CITY OF ALBUQUERQUE

**Re: Sowers Custom Cabinets, 7900 Jacs Place NE, Traffic Circulation Layout
Architect's Stamp dated 6-20-07 (D16-D2A1)**

Based upon the information provided in your submittal received 6-27-07, the above referenced plan cannot be approved for Building Permit until the following comments are addressed:

**Re: Sowers Custom Cabinets, 7900 Jacs Place NE, Traffic Circulation Layout
Architect's Stamp dated 9-07-07 (D16-D2A1)**

GRADING AND DRAINAGE PLAN

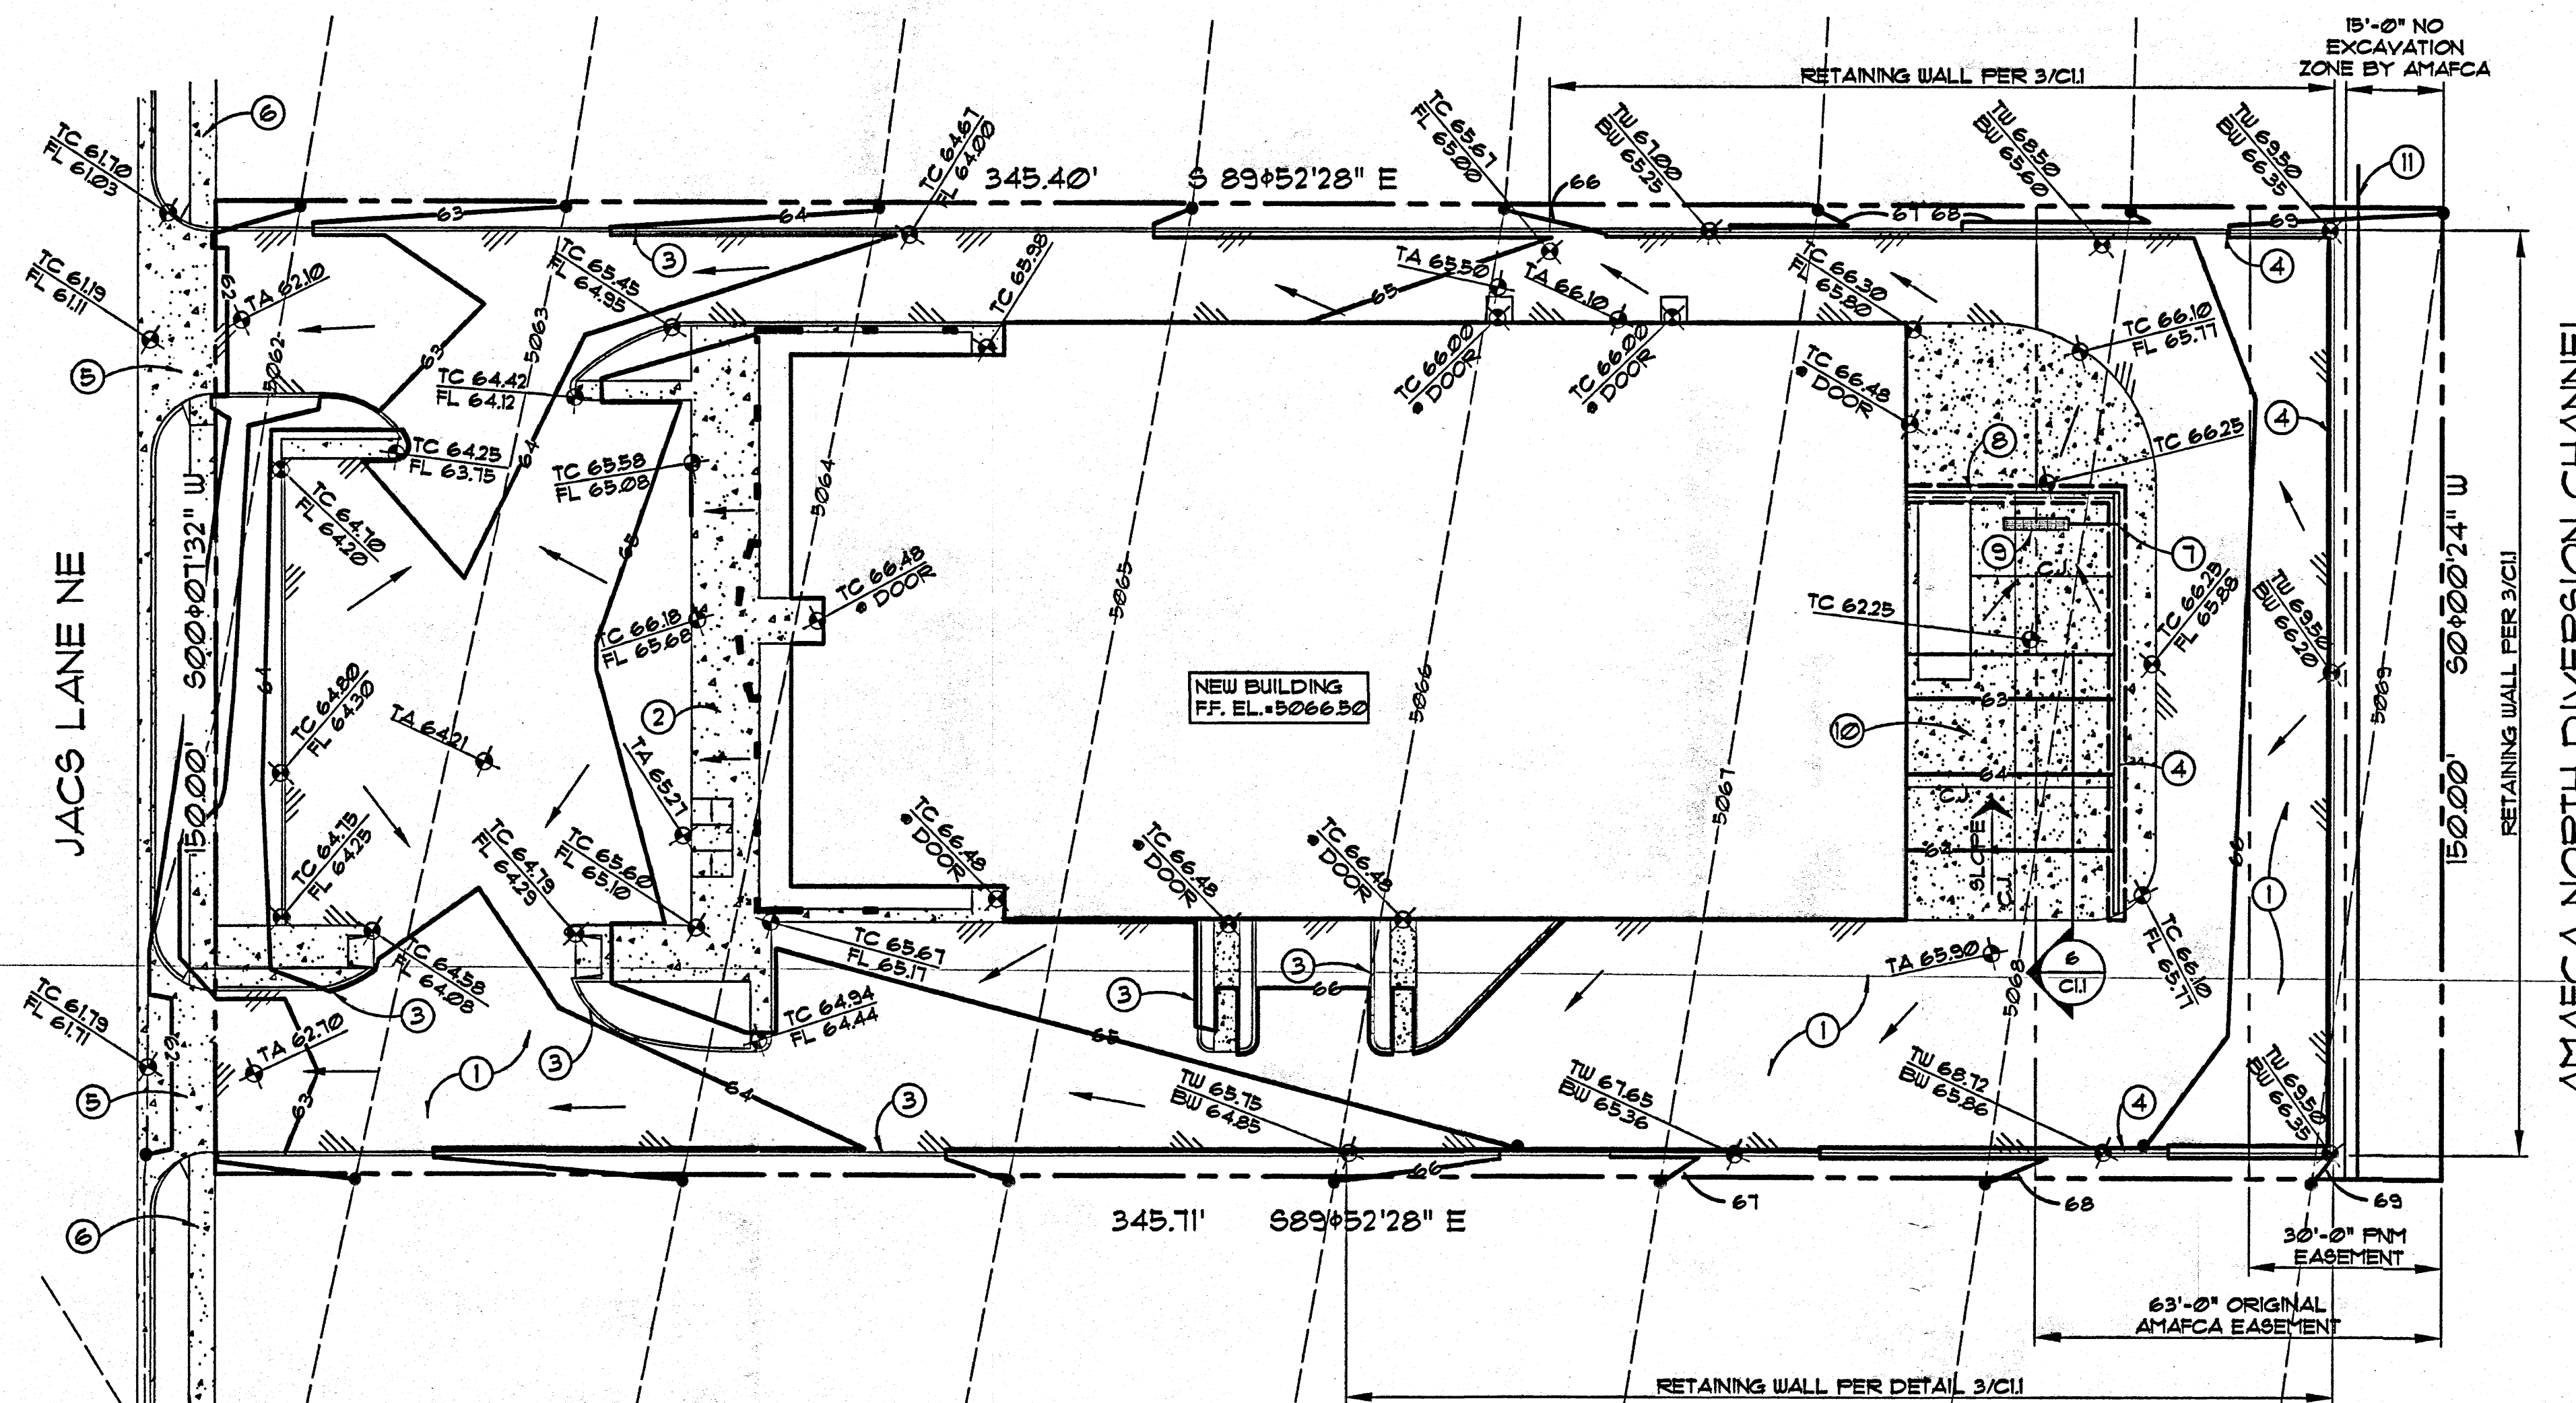
1. An AMAFCA approval letter for the retaining wall bordering their easement must be submitted with the plans.
2. Please verify the lot number and the name of the street.

1. If PNM has not been contacted yet, they should be consulted regarding the location of the retaining wall in the 30-foot easement. It looks too close to the gas line.
2. Change the call out for the 63-foot AMAFCA easement to "AMAFCA Excavation Easement".
3. I don't see all the section cuts for the details on Sheet C1.1. Are they on other sheets?
4. Section 5 for the drop inlet shows an inlet invert of 73.5. Note 9 calls out T.G. on the inlet of 62.08.

SITE PLAN
SCALE: 1"=20'-0"

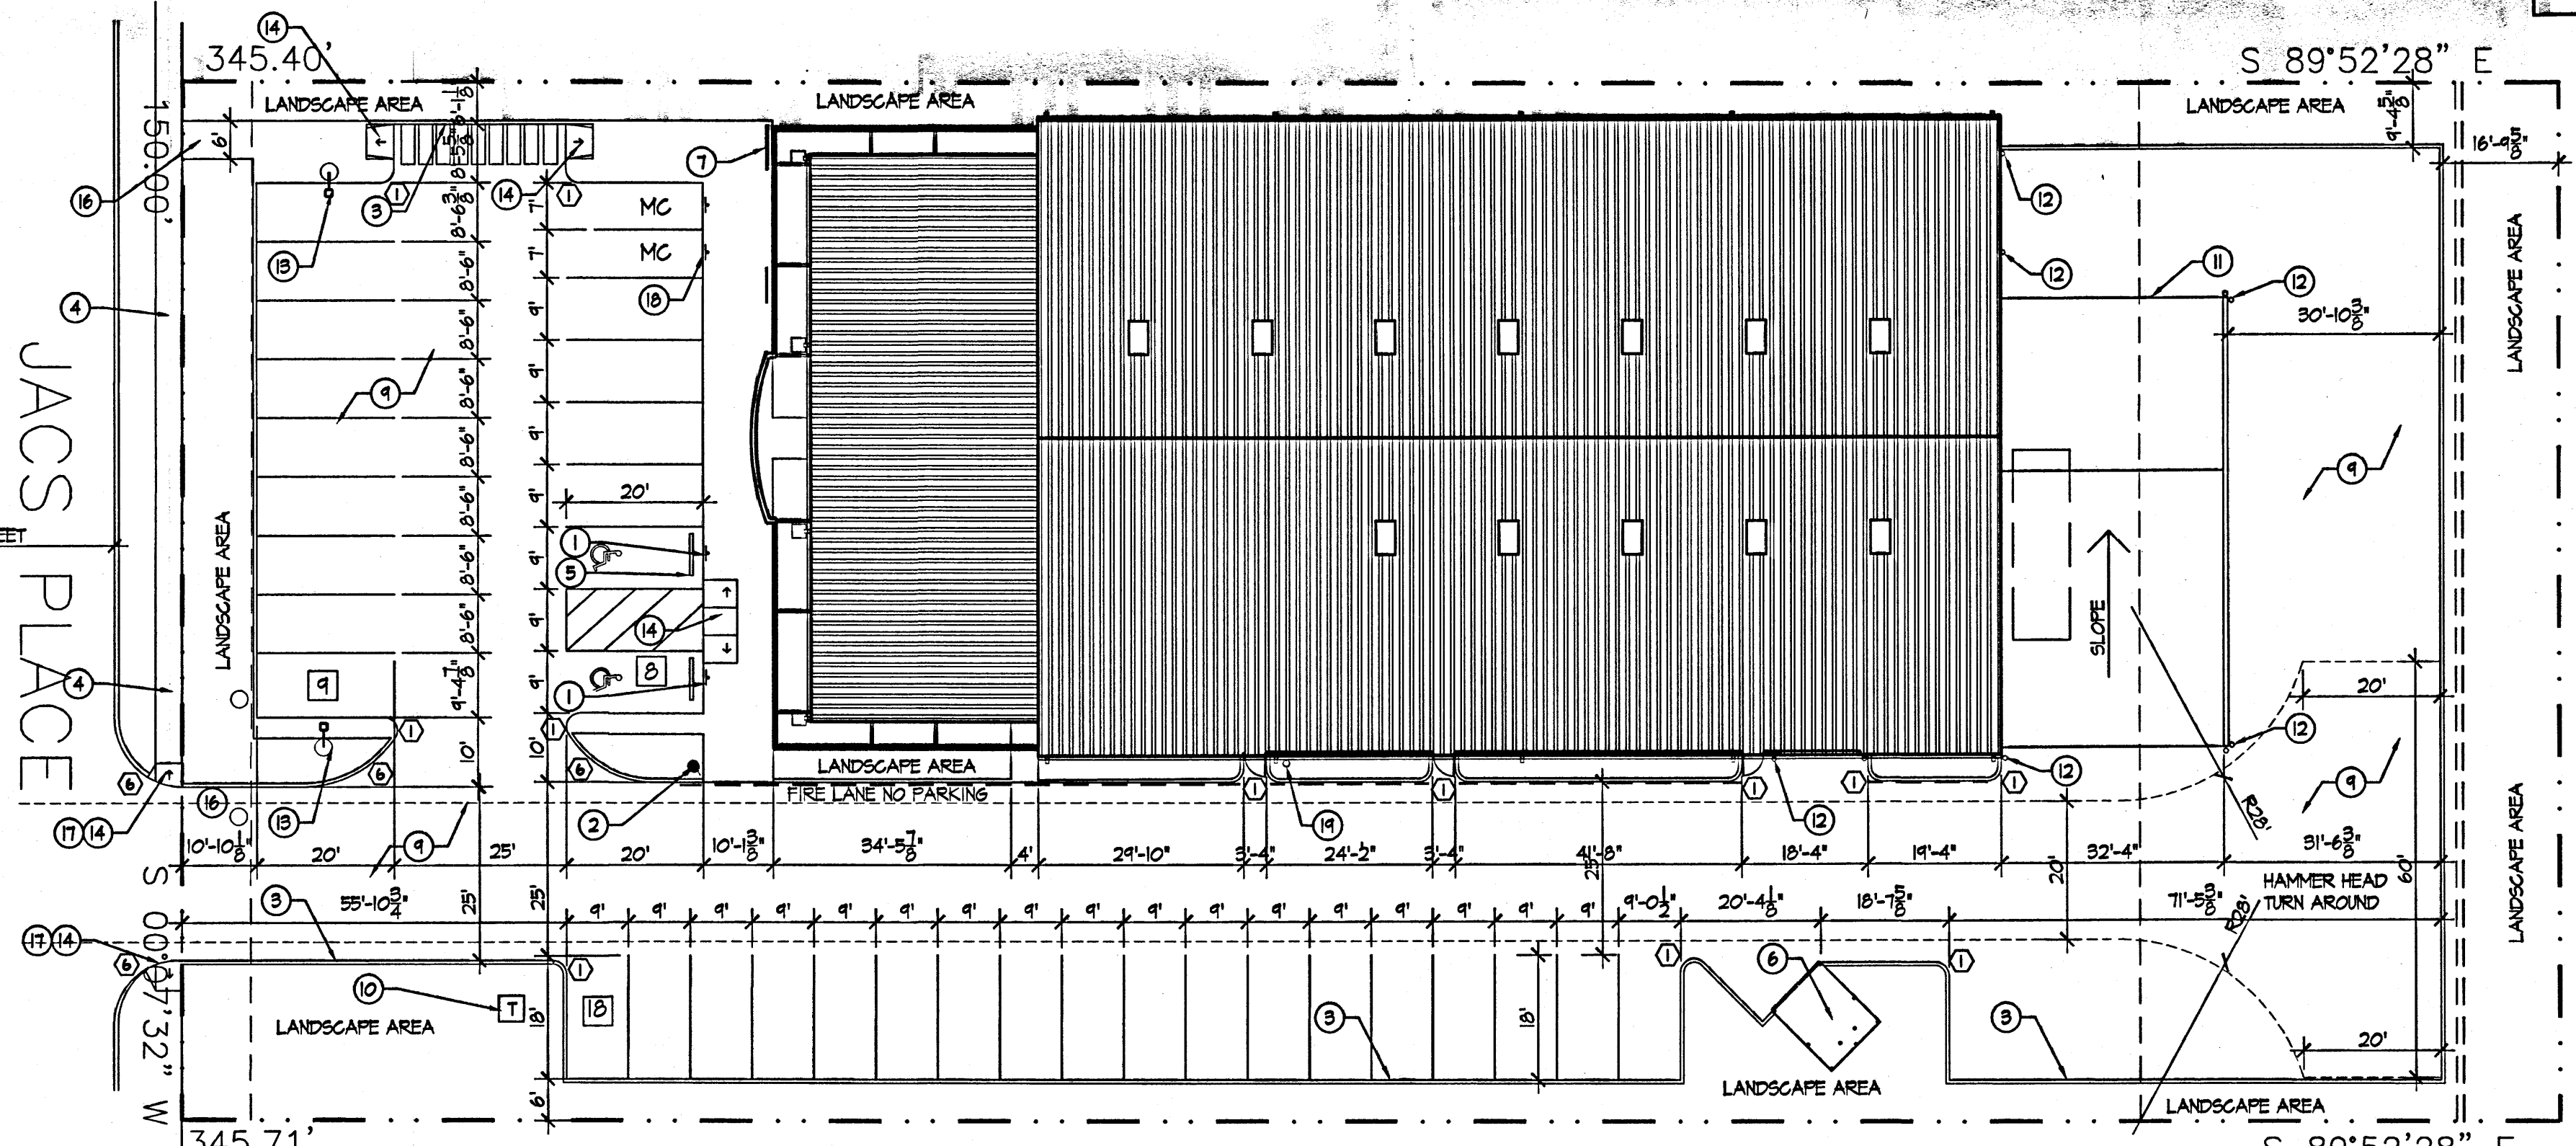
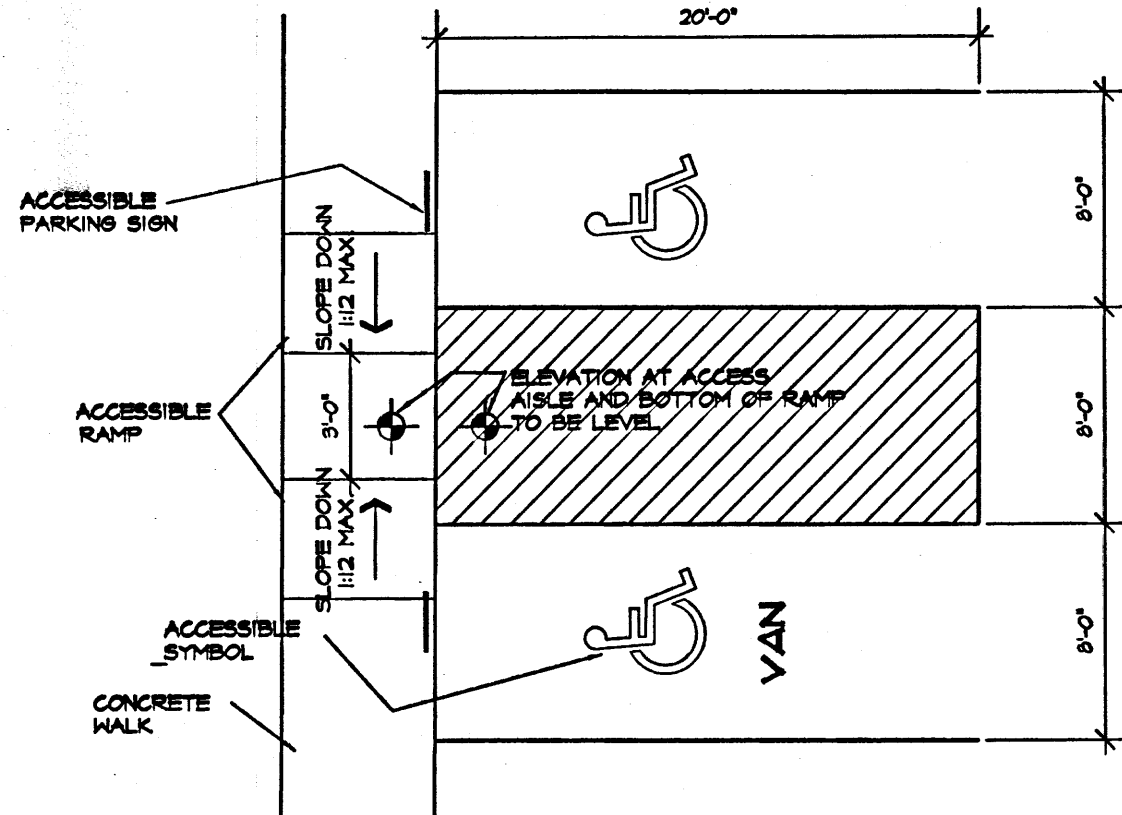
1. Please show the location of the nearest driveway on the adjacent lots.
2. The wheelchair ramps at the proposed entrances should be built according to keyed note 14.
3. Define width of all sidewalk.
4. The wheelchair ramp shown in detail 11 does not match the wheelchair ramp shown on the plan. Please amend the plan to match detail 11.

1. Please show the location of the nearest driveway on the adjacent lots.
2. For passenger vehicles, the minimum end island radius is 15 feet.
3. Provide build notes for the proposed entrances, referring to all appropriate City Standards by standard number.
4. The proposed light pole (keyed note 13) appears to interfere with the pedestrian path.
5. Verify that the pedestrian connection does not interfere with the wheelchair ramps.
6. Please update your parking calculations; only 31 parking spaces are provided.
7. The two northernmost "One Way Do Not Enter" signs should be removed.
8. One-way aisles typically have a minimum width of 20 feet to meet the fire code. Please check with the Fire Marshal to determine if the current width is adequate.

2 of the One Way Do Not Enter signs (northmost)
in the wrong place

One way aisle typically 20' min in width

Update Parking calculations - only 31 parking
spaces are provided

15' min radius for passenger vehicles

Build notes for proposed entrances

The ^{proposed} light pole (key note 13) appears to
interfere w/ the pedestrian path

Verify that the pedestrian connection does not
interfere w/ the wheelchair ramps
